Application for Planning Permission for Works or Extension to a Dwelling

Development Proposed creation of new 1st floor & raised tiled roof.

Location 1 Downlands Close Pagham

sheet 5 of 5

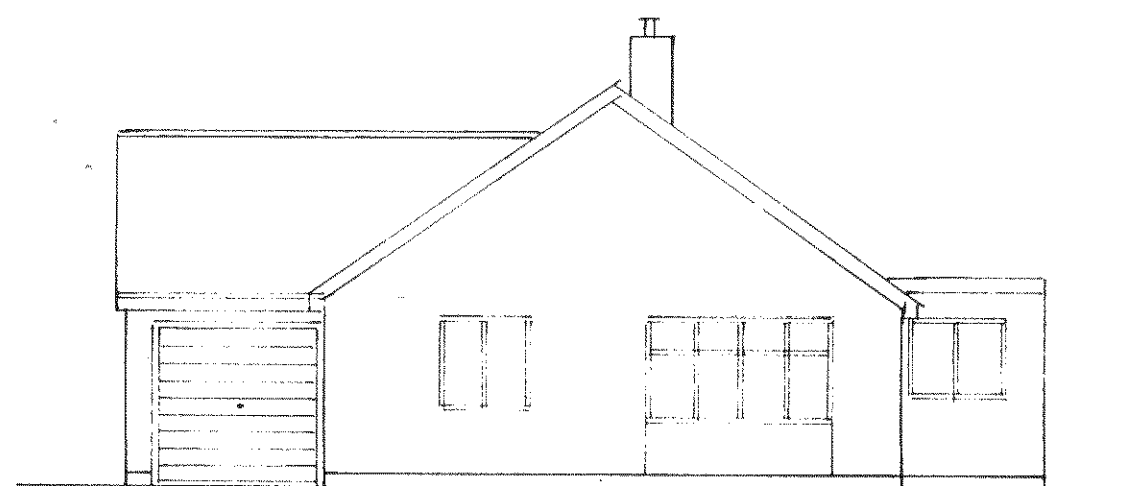
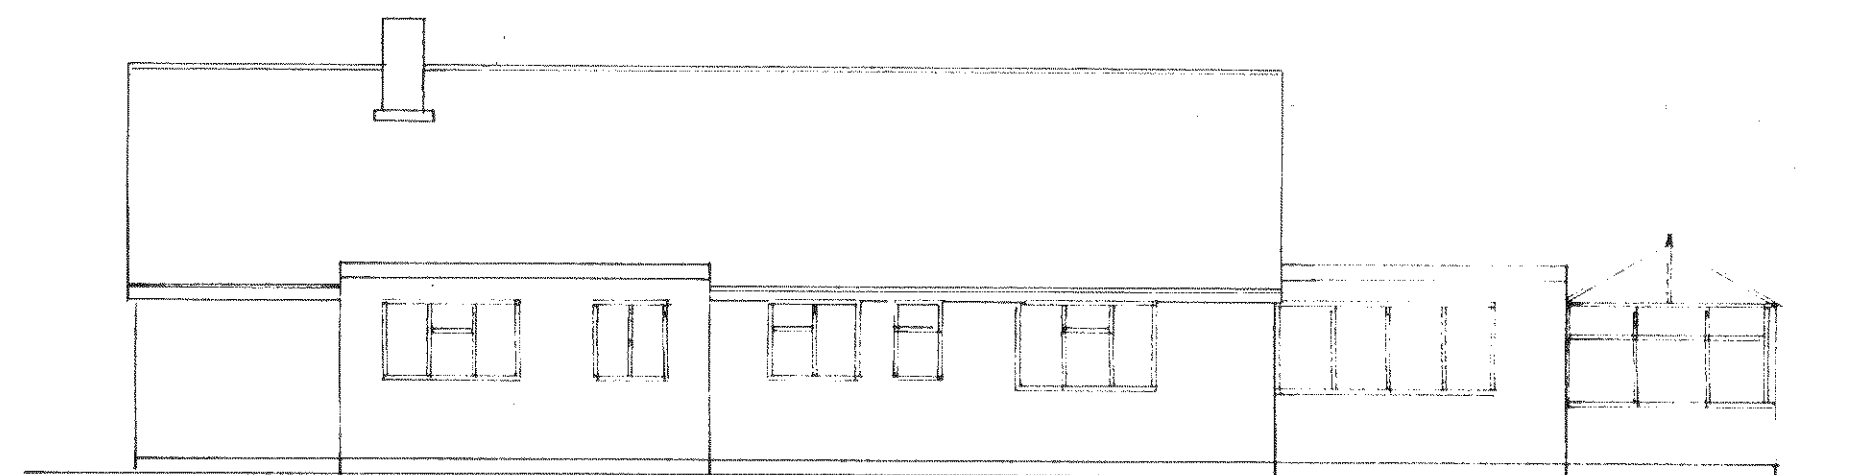
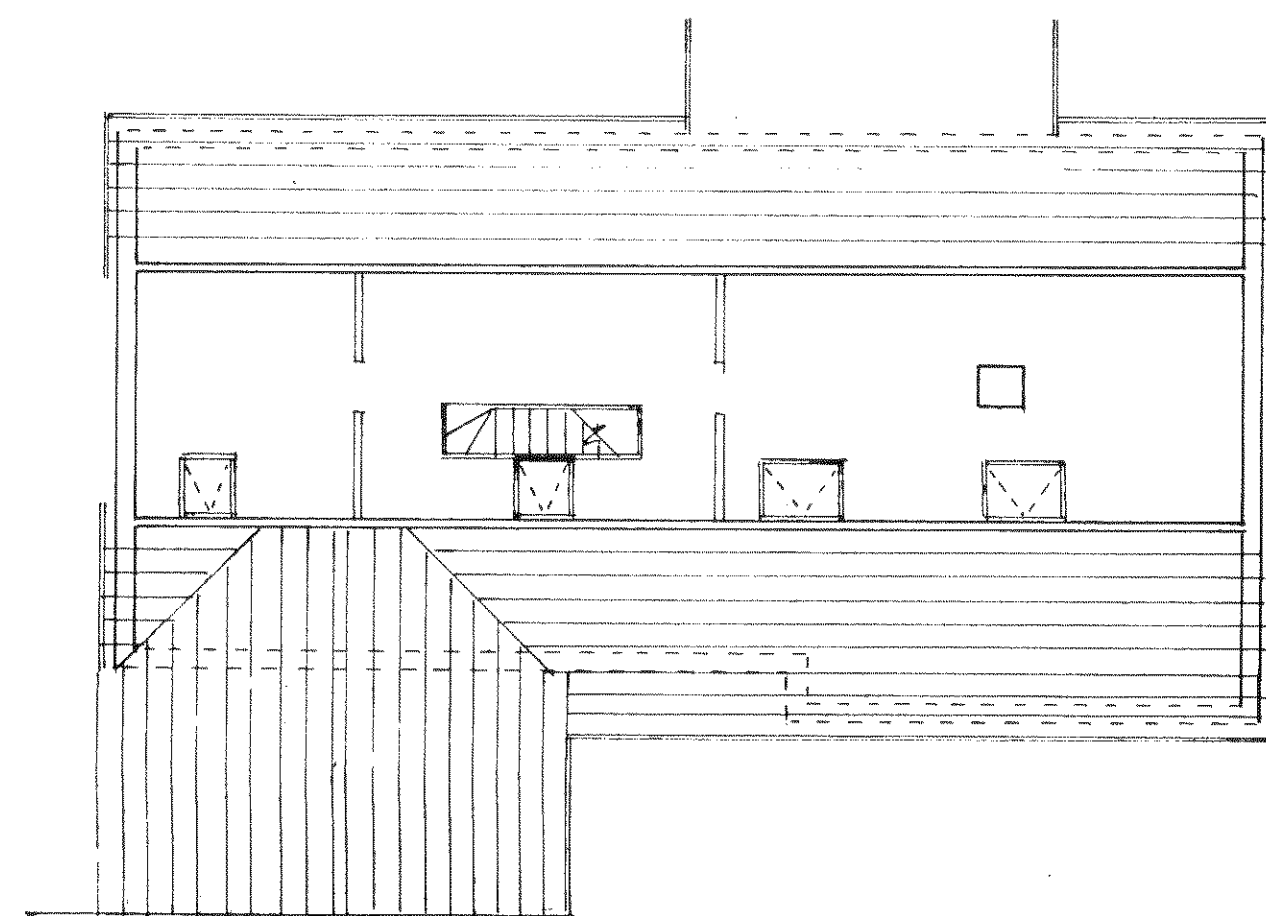
- ✓ Please submit 1 electronic or 3 paper copies of revised existing and proposed south elevations and the plans submitted do not accord with the floor plans, there appears to have been a window omitted in accordance with the guidance notes available on our website detailed below (click on National List).
